# **Suffolk County Council (20031377)**

Response by Suffolk County Council to Action Point No. 7  
Consequent Upon ISH4 on Environmental Matters and the draft  
Development Consent Order (dDCO)

## **Sunnica Energy Farm (EN010106)**

**3 March 2023**

**Sheet 21 of 24**

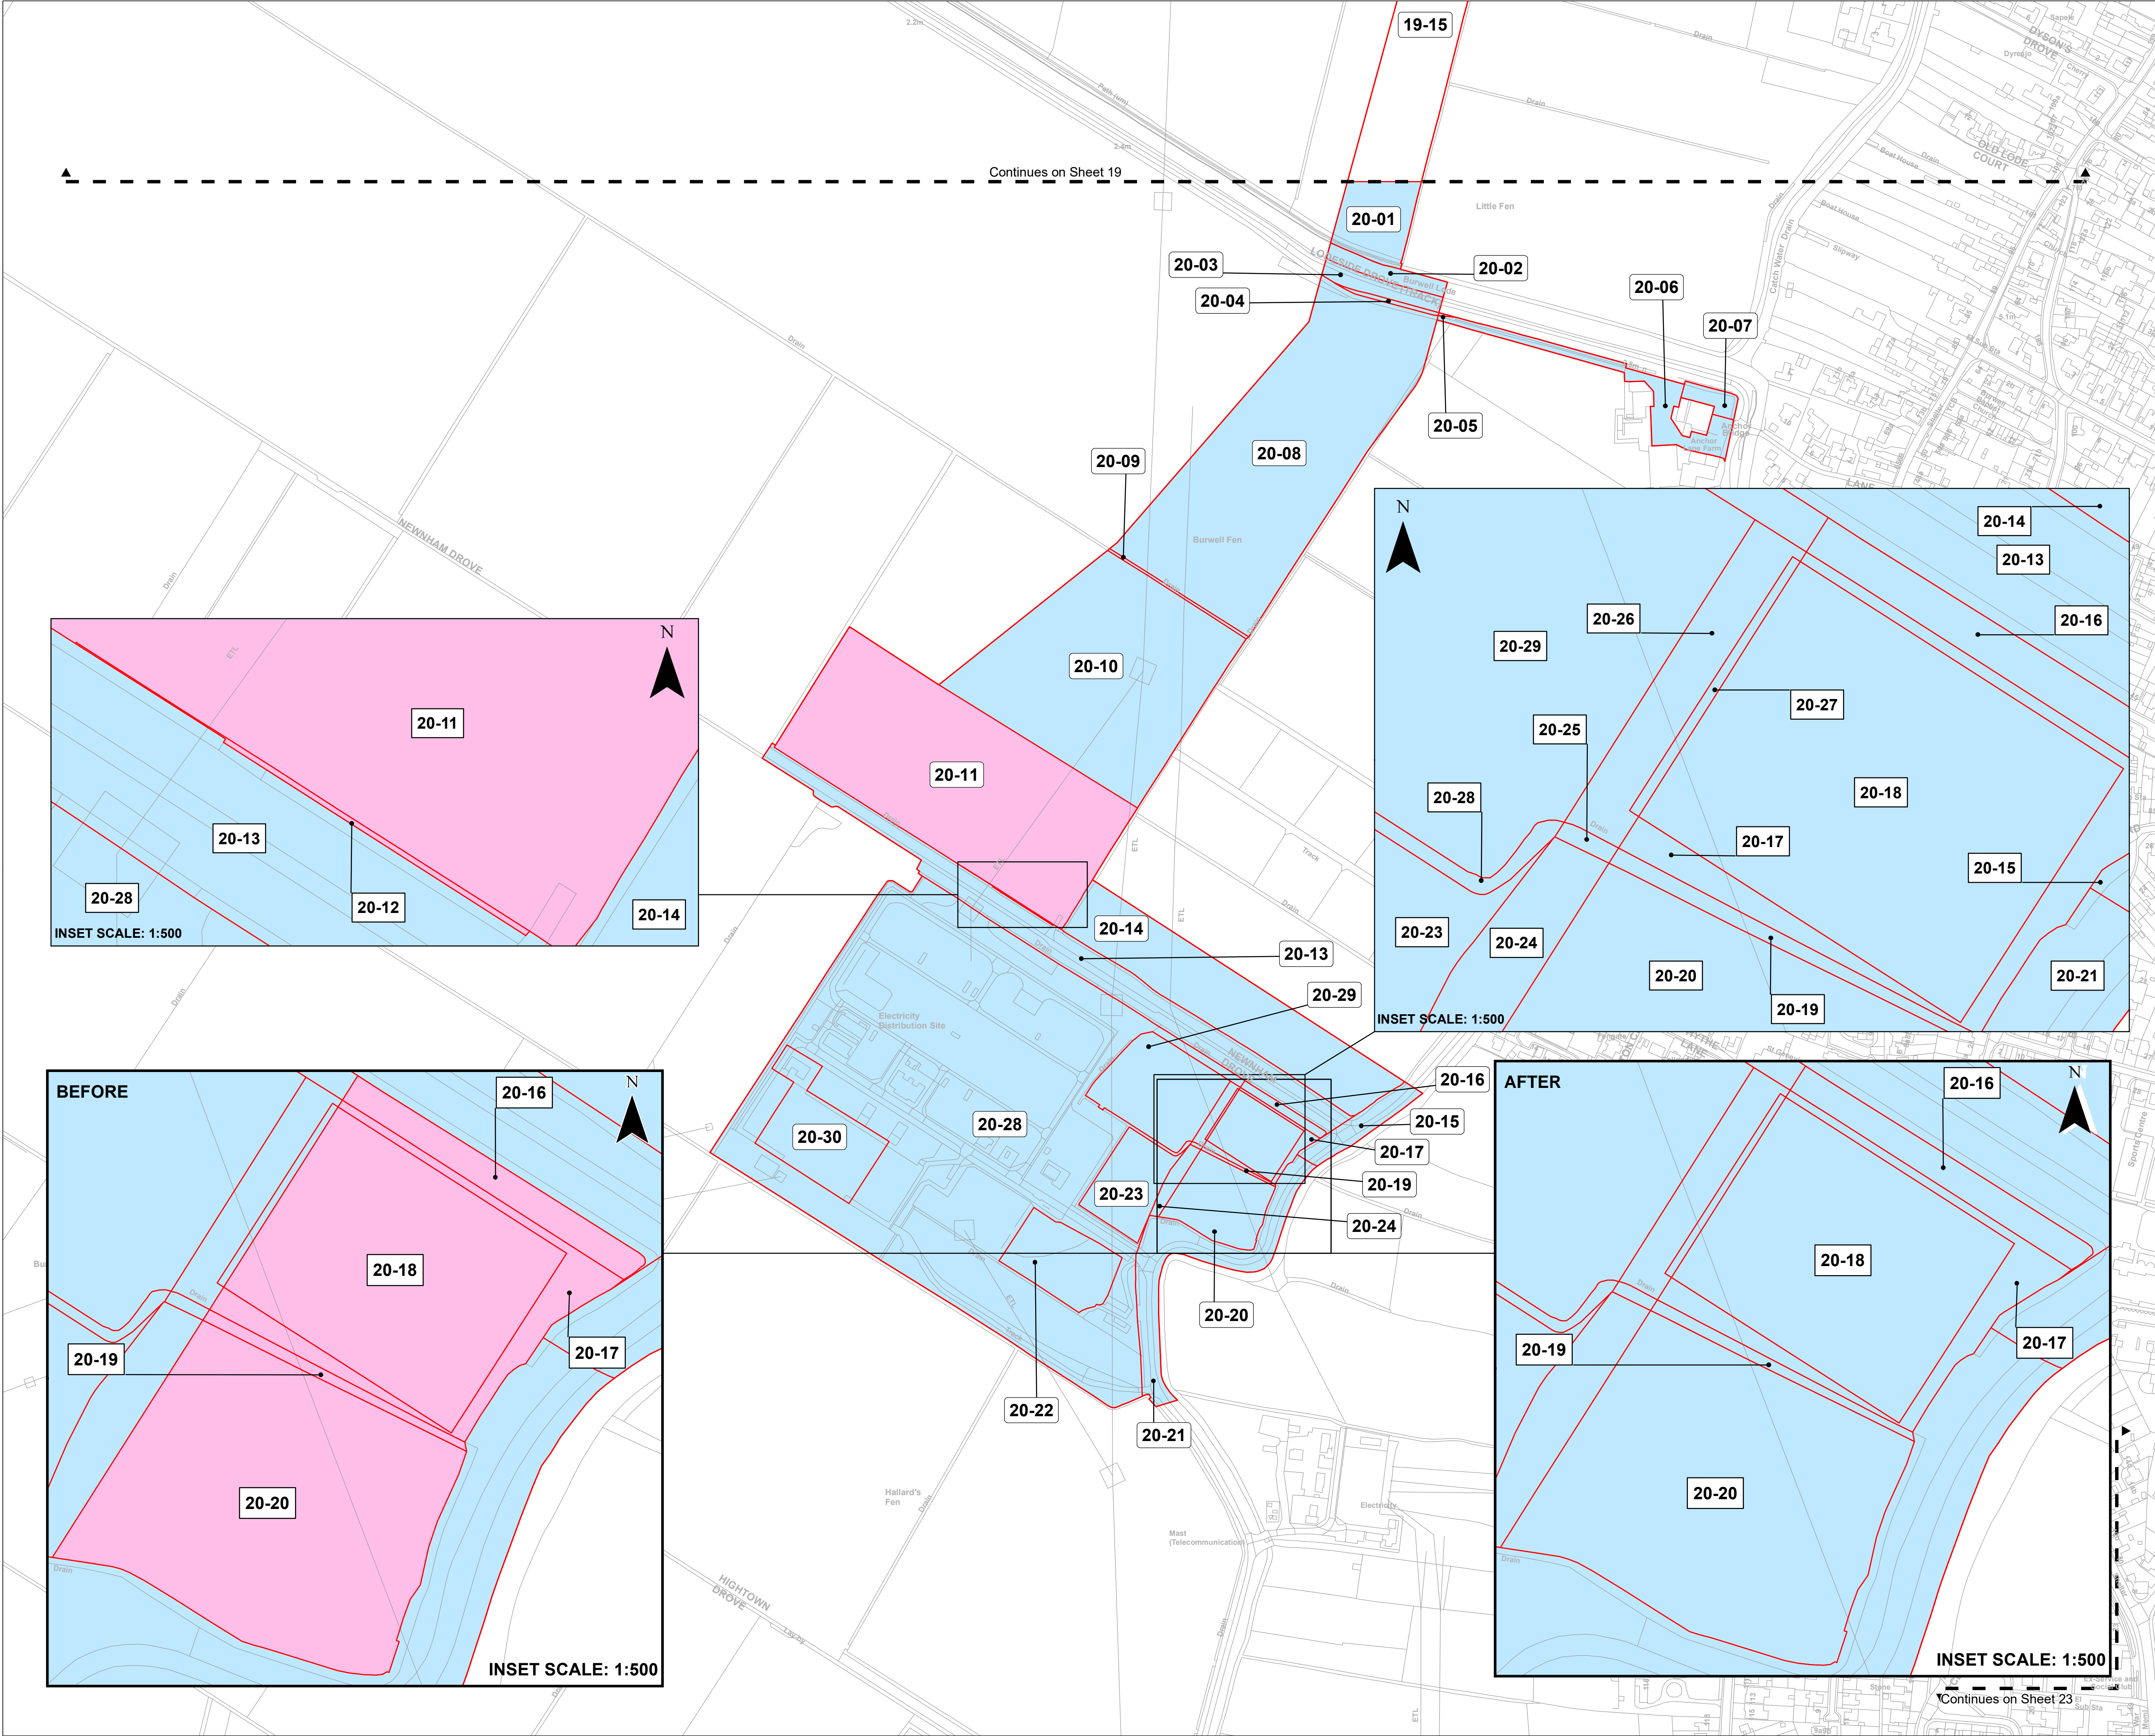
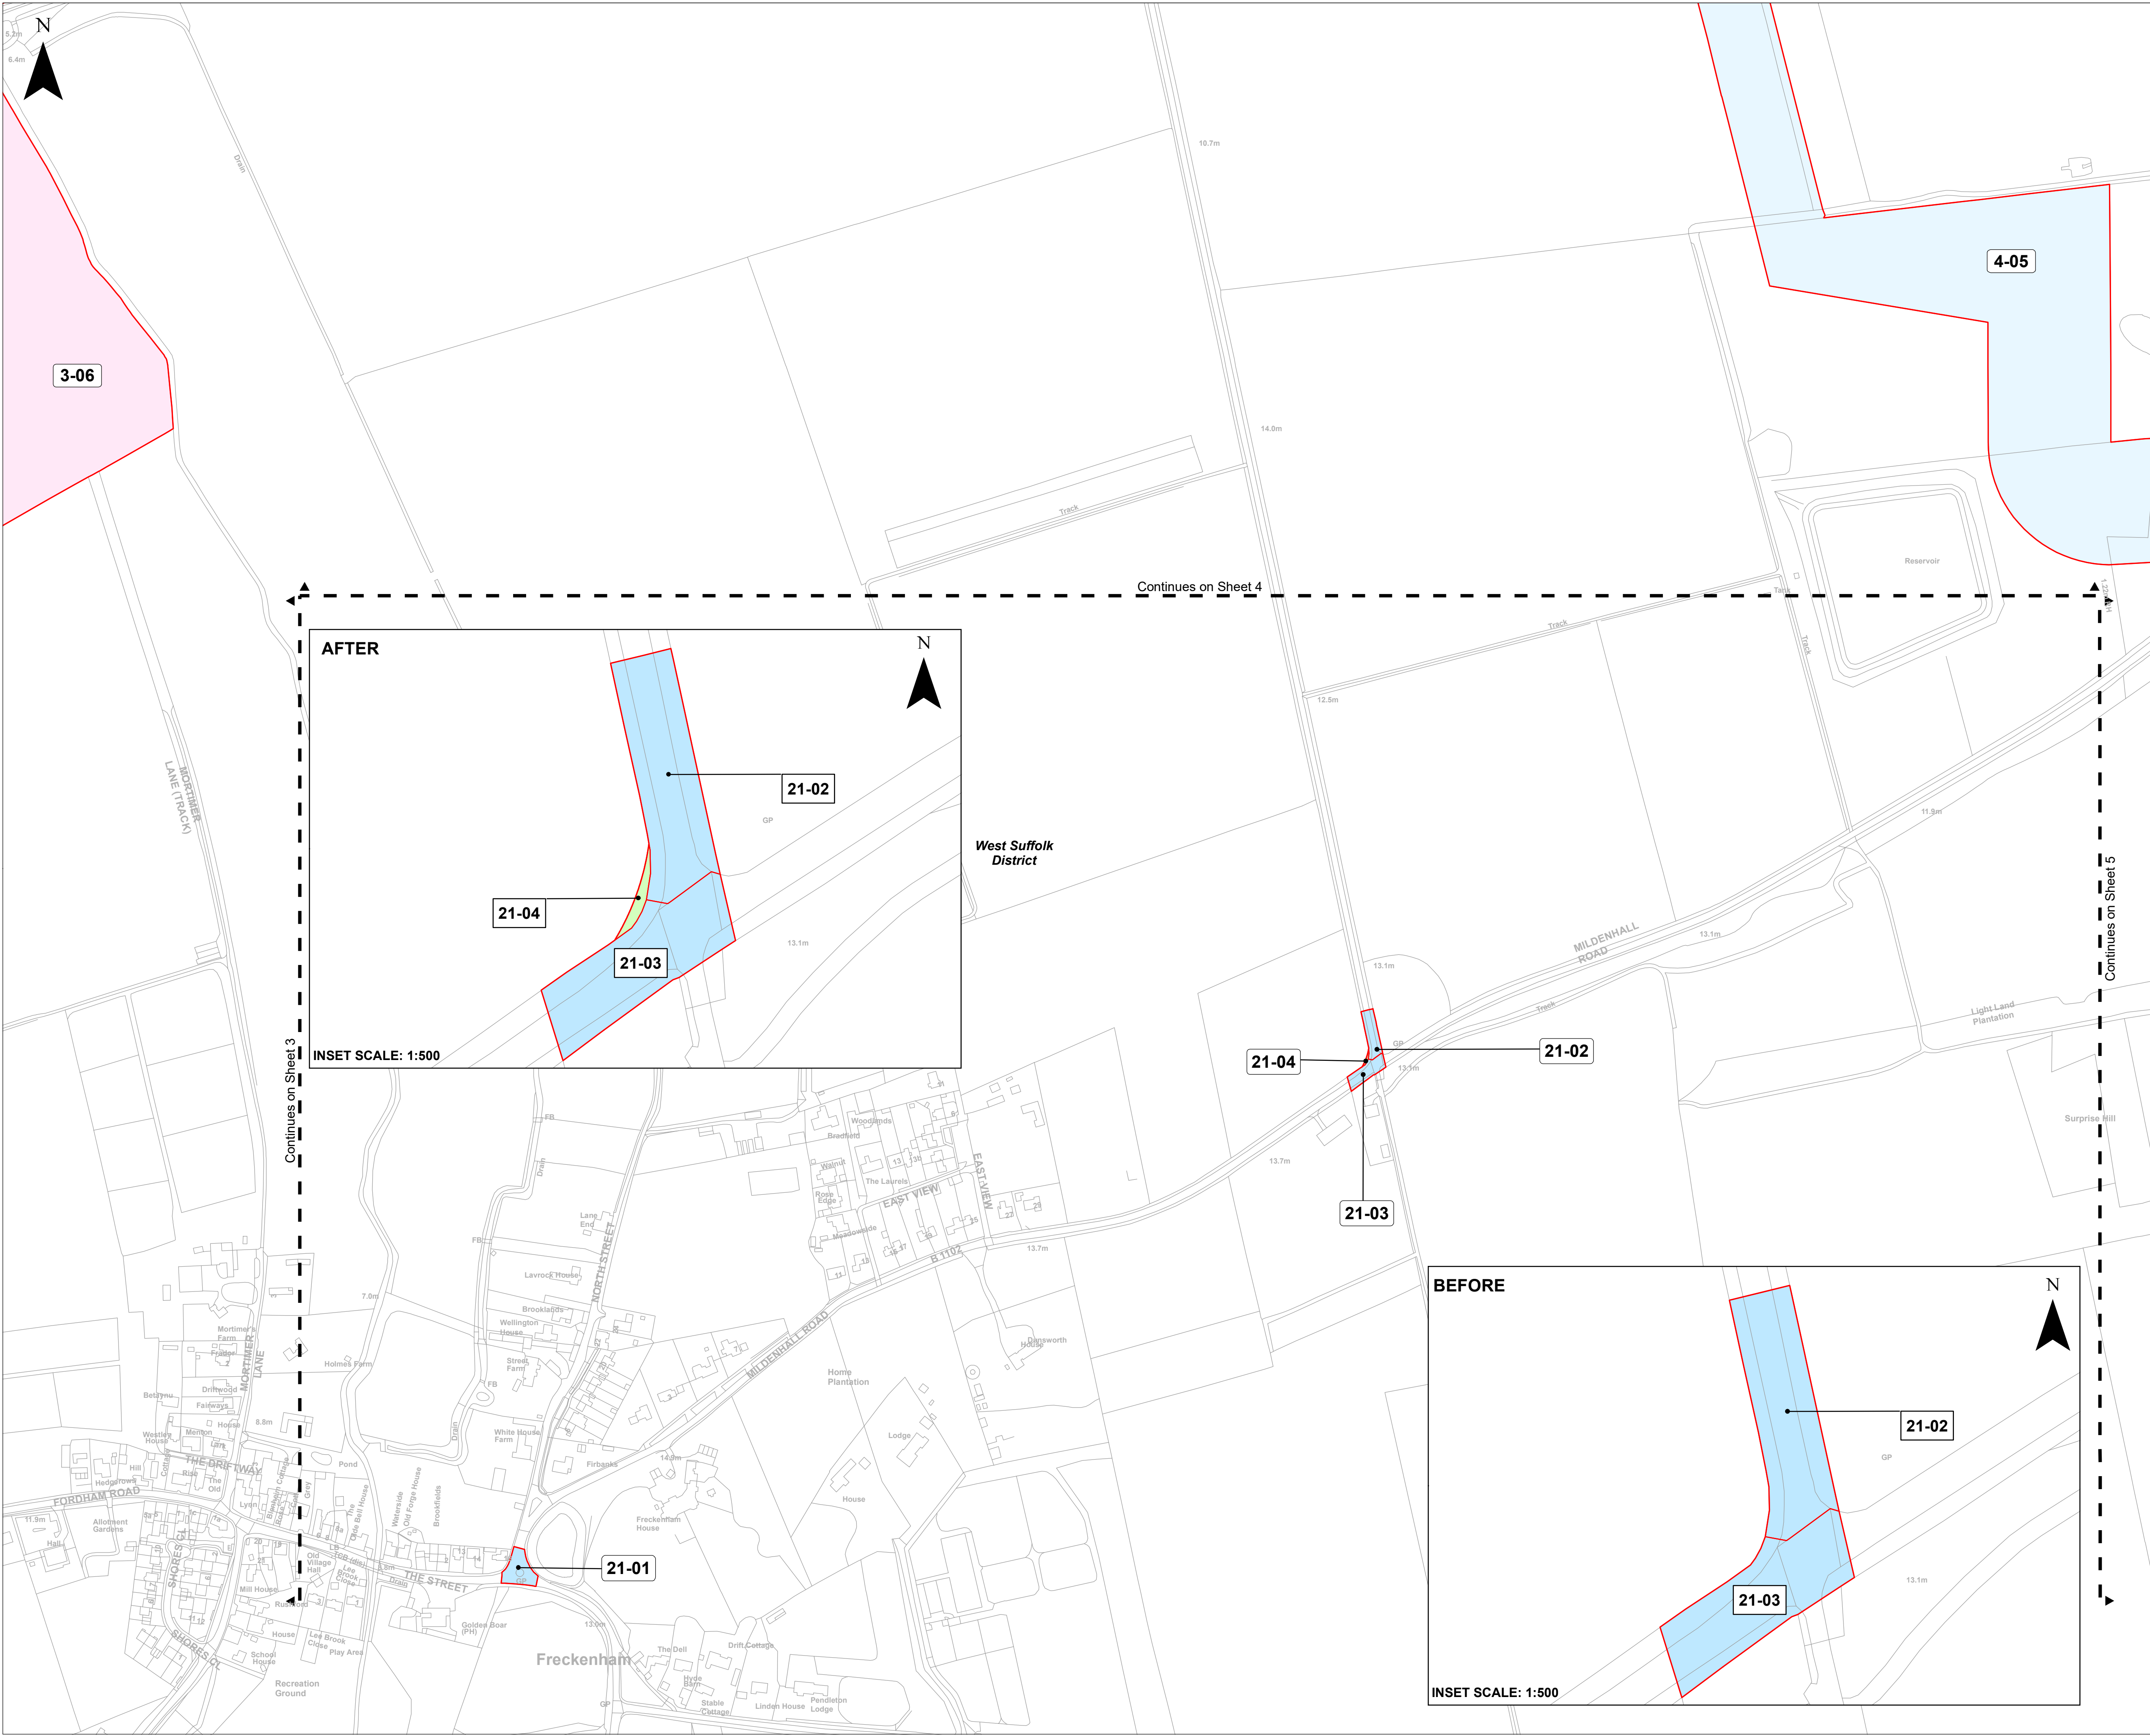
**(aa) Other than works comprised within or for the purposes of sub-paragraph (a)(iii), Work No. 1A works must not be constructed on the land labelled plots 2-02 and 3-01 on the land plans.**

**(ba) Other than works comprised within or for the purposes of sub-paragraph (b)(iii), Work No. 1B works must not be constructed on the land labelled plots 5-03, 5-07, and 7-01 on the land plans, and**

**(ca) Other than works comprised within or for the purposes of sub-paragraph (c)(iii), Work No. 1C works must not be constructed on the land labelled plots 10-21, 11-07, 11-08, 12-02, 13-02, 13-03, 13-04, 14-01, 14-02 and 14-03 on the land plans,**
